**Subject:** Rezoning Petition Review

**Date of Review:** December 22, 2021 (*Revised February 25, 2022*)

**Rezoning Petition #:** 21-201

**Location of Property:** Approximately 1.15 acres located in the northwest quadrant of the intersection of Weddington Ave and Bascom St, east of E 7<sup>th</sup> St.

SHEET NAME
REZONING SITE PLAN

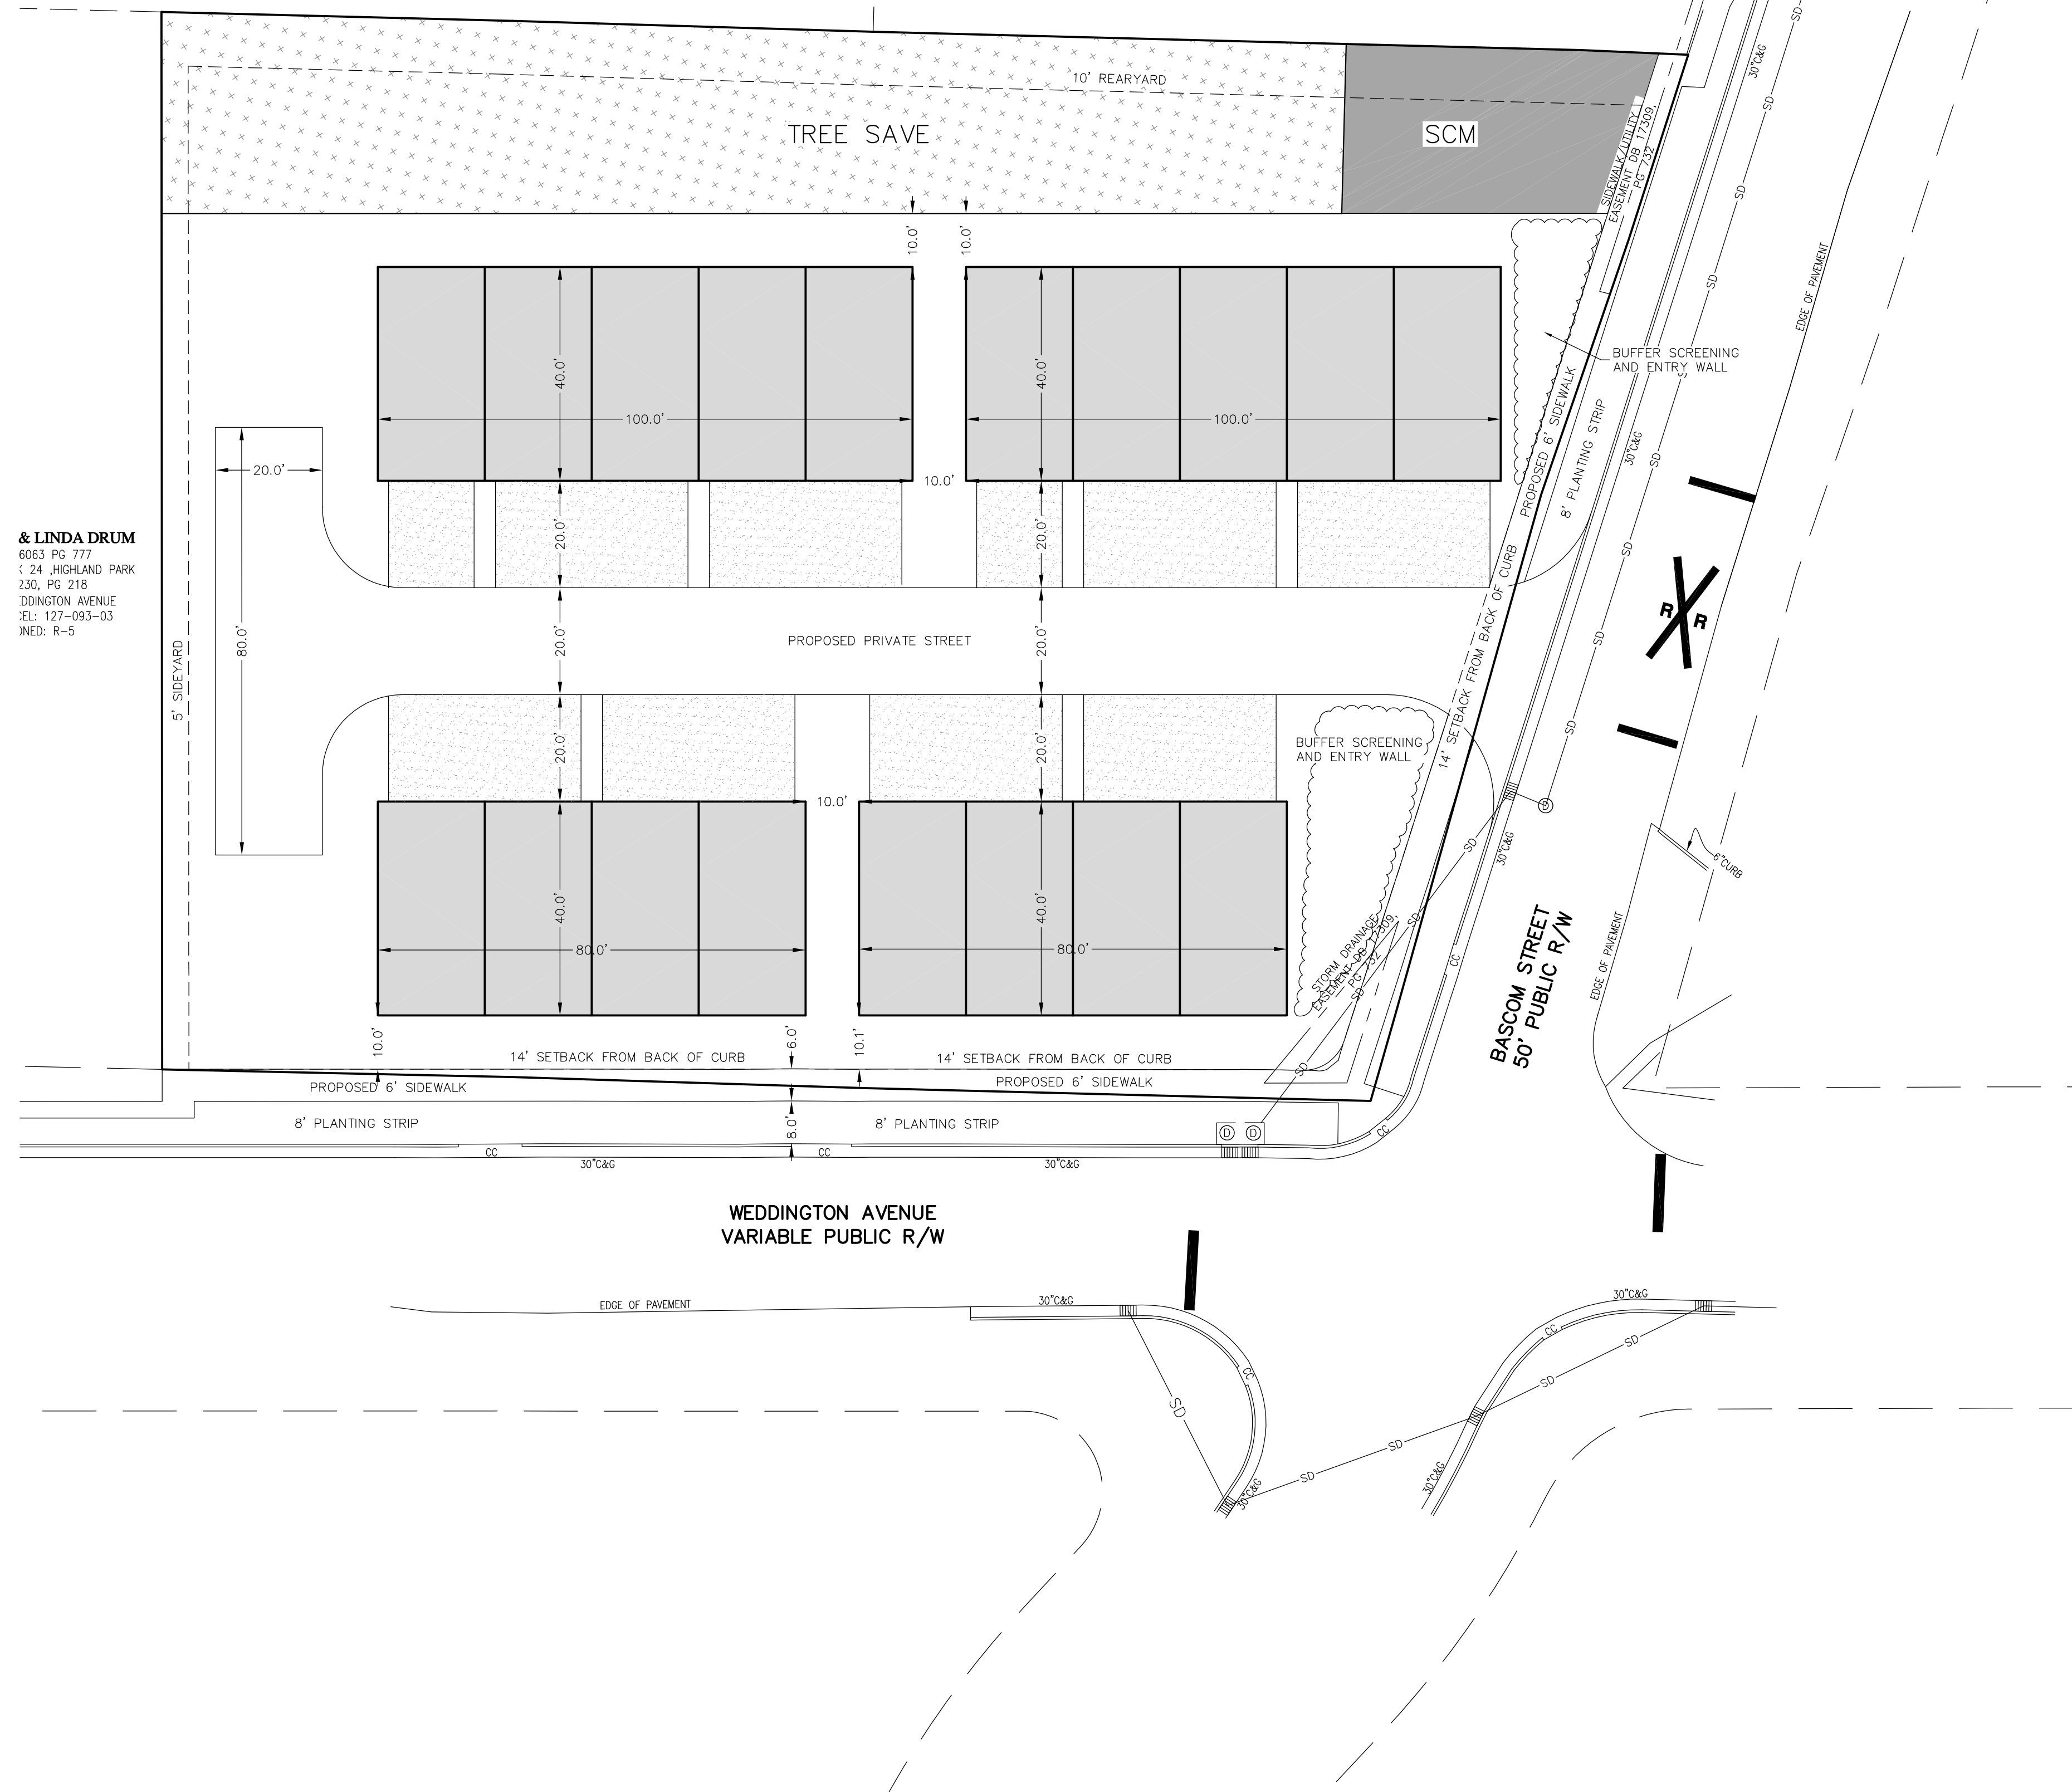
The proposed rezoning plan sheet indicates a proposed location for storm water management. Please include the following notes on the plan sheet under "Environmental Features": *The location, size, and type of storm water management systems depicted on the Rezoning Plan are subject to review and approval as part of the full development plan submittal and are not implicitly approved with this rezoning. Adjustments may be necessary in order to accommodate actual storm water treatment requirements and natural site discharge points.*
